Ribble Valley Borough Council

App. No: 3/2026/0089

Address: Land at Highmoor Farm, Clitheroe

Proposal: Reserved Matters application relating to appearance, landscaping, layout and scale of 124 residential dwellings together with public open space and attenuation pond following outline planning permission 3/2020/0601

REV	DESCRIPTION	DATE	INT
 <p>Morris Homes (North) Limited Morland House Altrincham Road Wilmslow Cheshire SK9 5NW Tel: (01625) 544 444 Fax: (0845) 833 1845</p>			
330 Title HIGHMOOR FARM CLITHEROE			
Dwg Title ADOPTABLE HIGHWAY PLAN

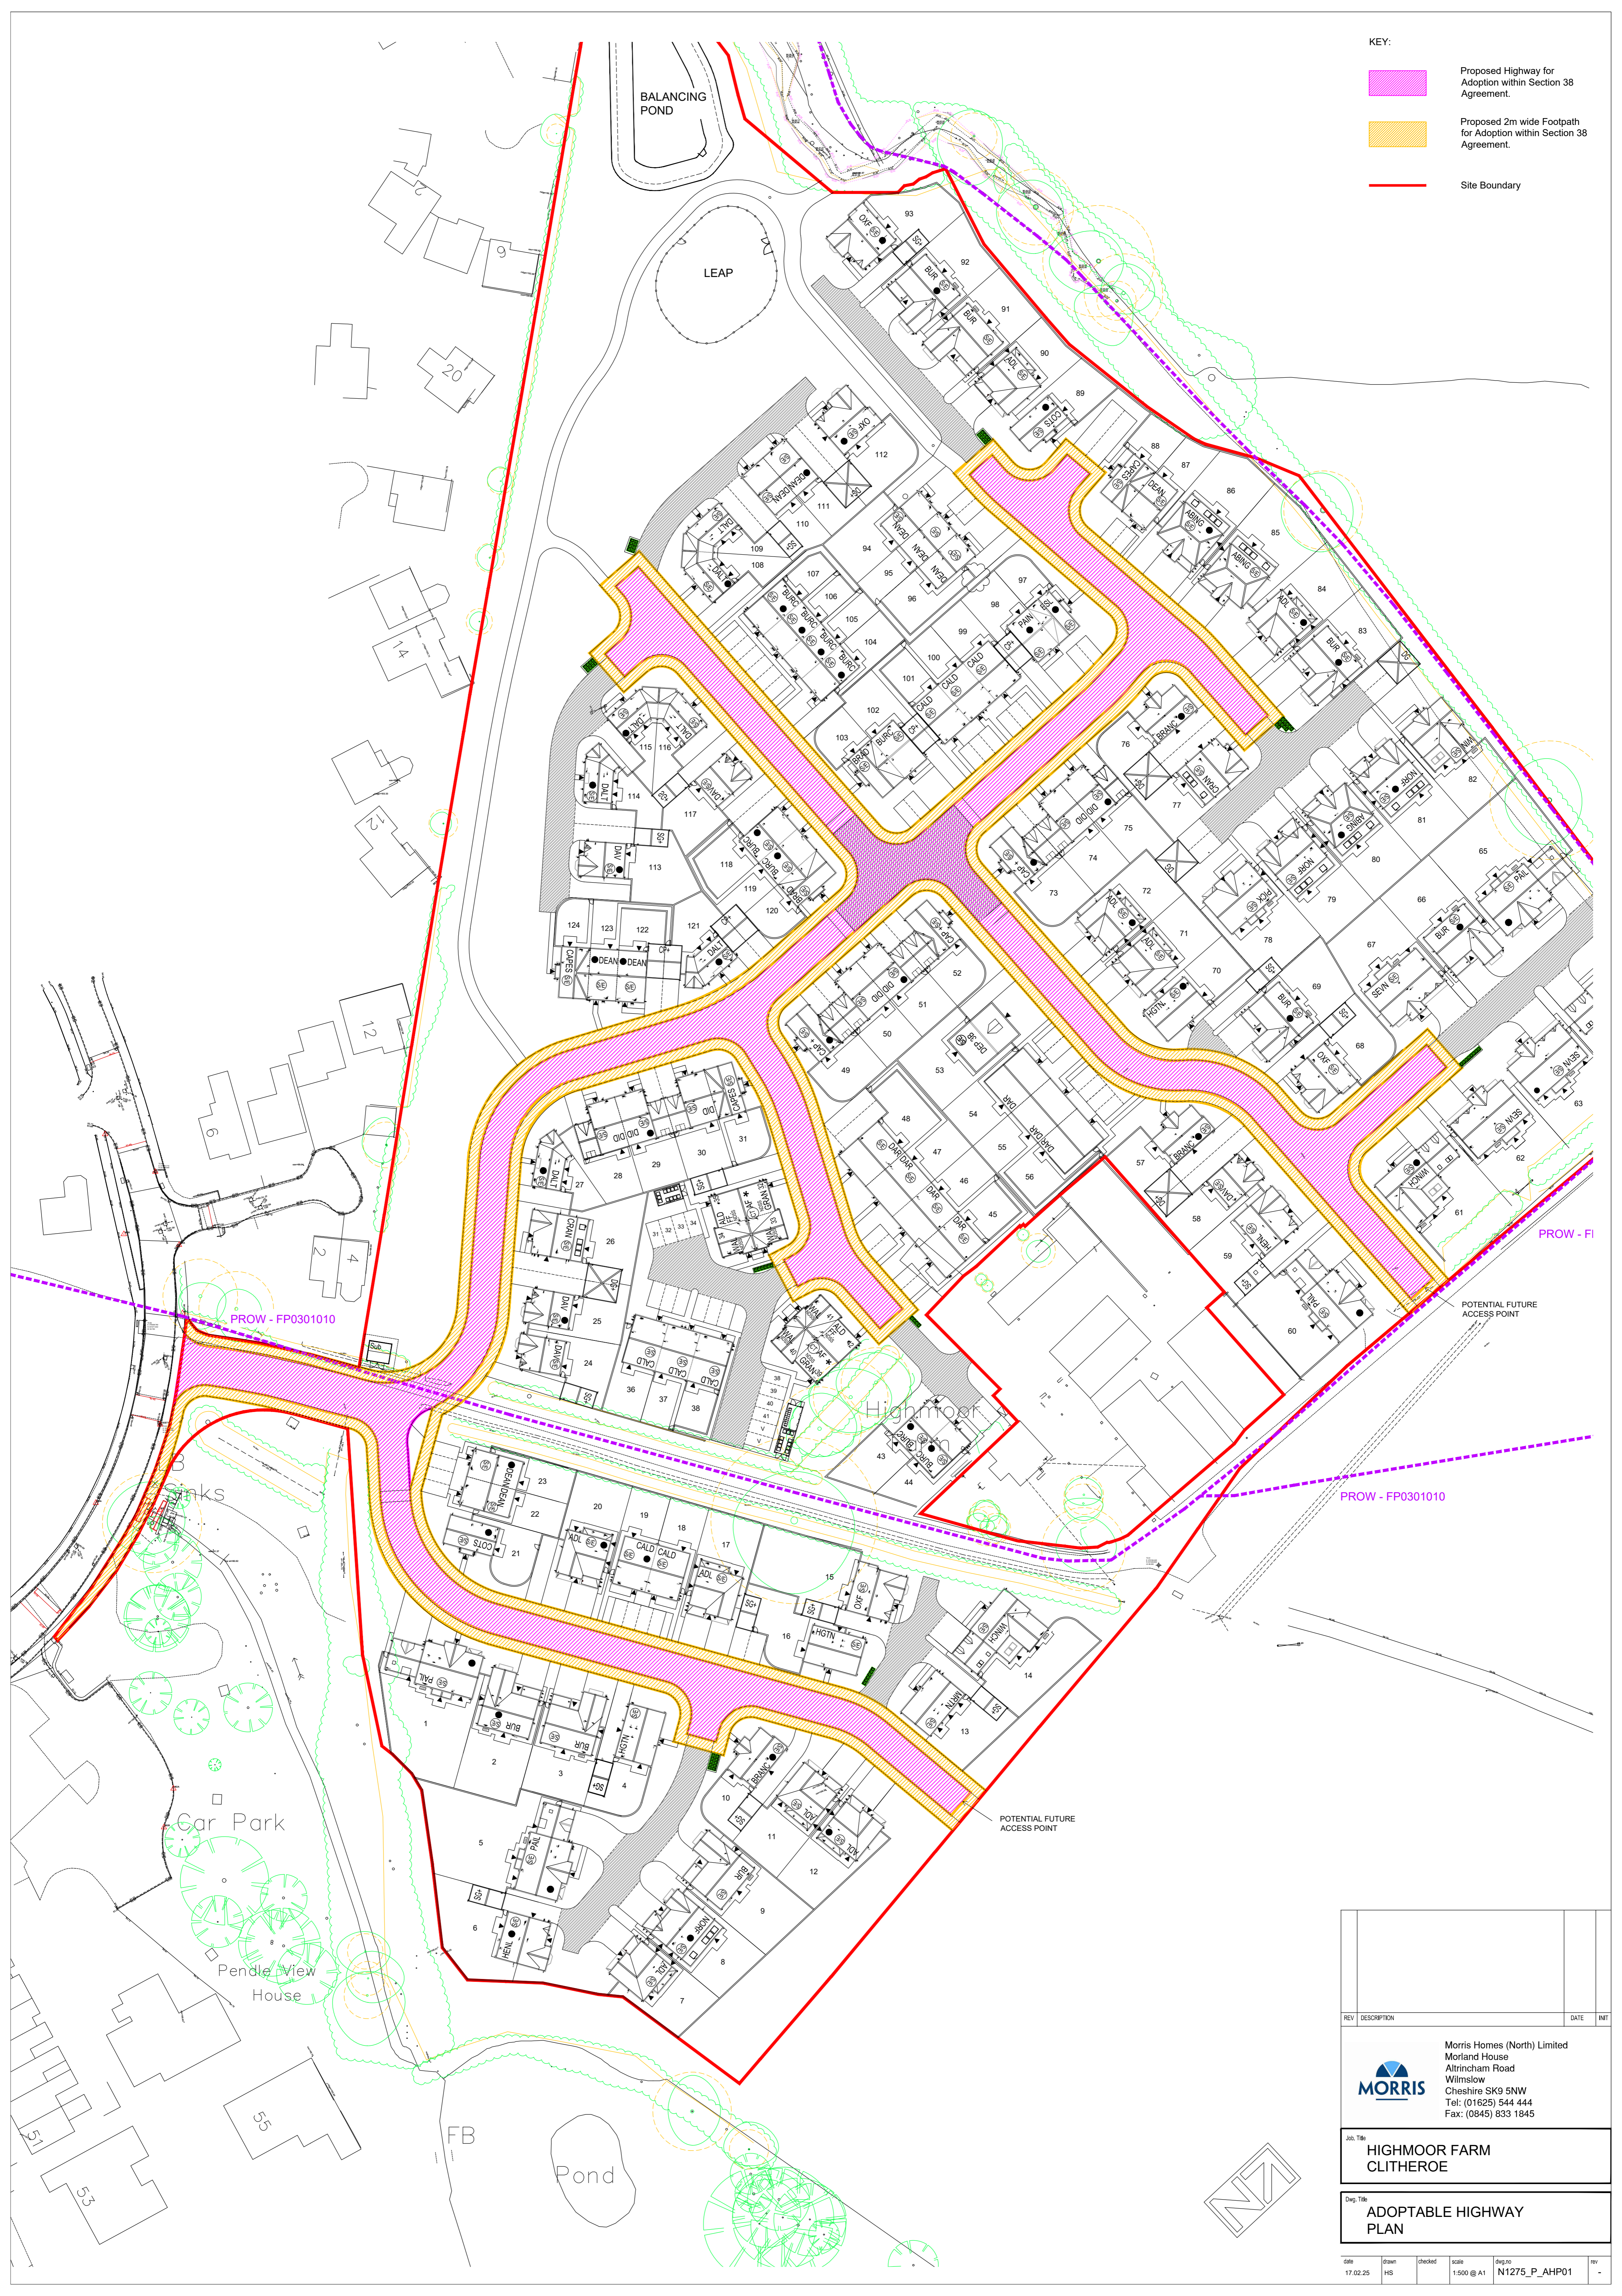
The first 40m of the estate road is proposed at 7.3m wide and reducing to 5.5m wide with 2m wide footways to both sides. We note that the outline application requires the widening of Highmoor Park to 7.3m however we have had discussions regarding this being reduced to 6.5m.

Should this is approved then we would request that the first 40m of the estate road matches the width of Highmoor Park i.e either 7.3 or 6.5m.

There are two points indicated for future extensions on the southeastern boundary designed to adoptable standards to the ownership edge.

Subject to the surface water proposals, the proposed layout is considered to be designed to adoptable standards and would seek be suitable to formally adopt under S38 Highways Act 1980.

FP0301010 crosses the proposed estate road close to plots 23-24. The first 5m of the track running east towards Highmoor Farm, should be paved to avoid debris being tracked onto the estate road and with dropped kerbs/tactile paving where it crosses the estate road.

FP0301009 runs along on the northeast boundary of the site partly inside partly outside the red edge. This footpath between the eastern site edge and Bracken Hey will require upgrading with a 2m wide stone surfaced path.

The Landscaping drawing shows the hedge along this boundary conflicts with the footpath and a clear 2m width must be provided, from the edge of the grown-out hedge and not be root base. A drawing showing this footpath is requested to clearly show this route along the rear of the plots 64-65, 82-93.

Drawing file: planx_downloads / 26_0089_WMS01_Waste_Management_Strategy_20Feb26.pdf

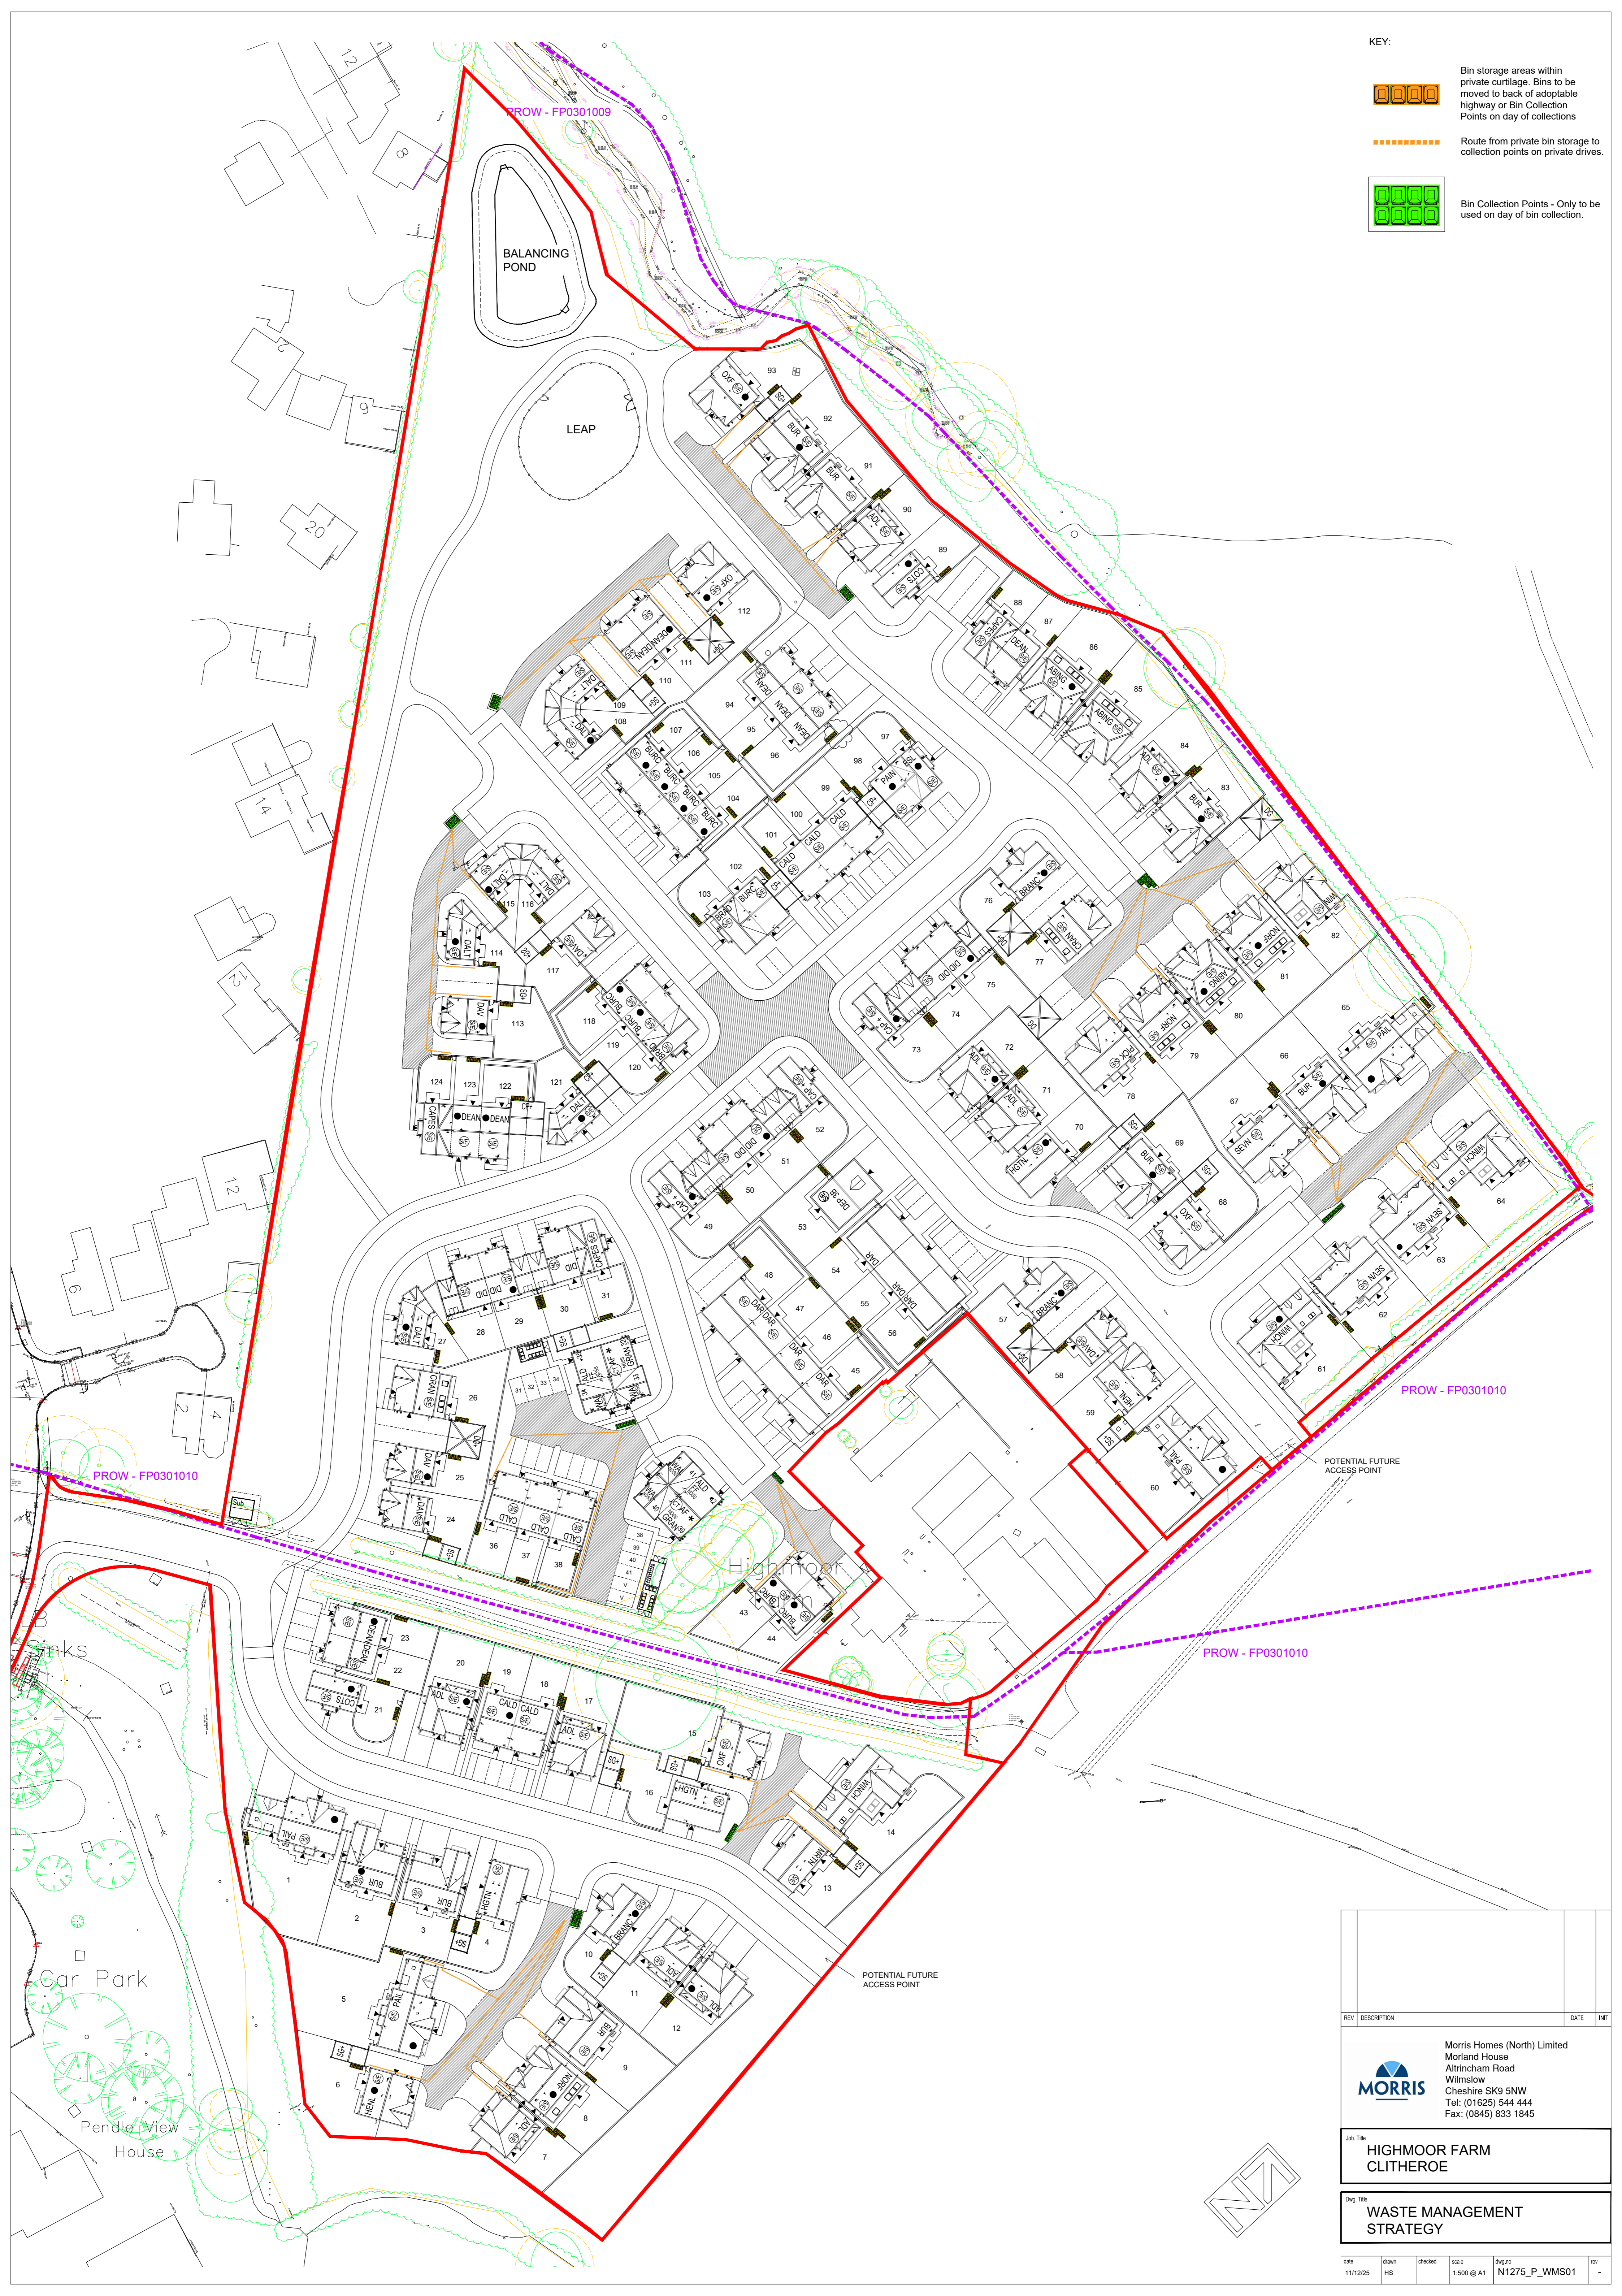
Swept path analysis for a 11.2m long refuse wagon should be provided.
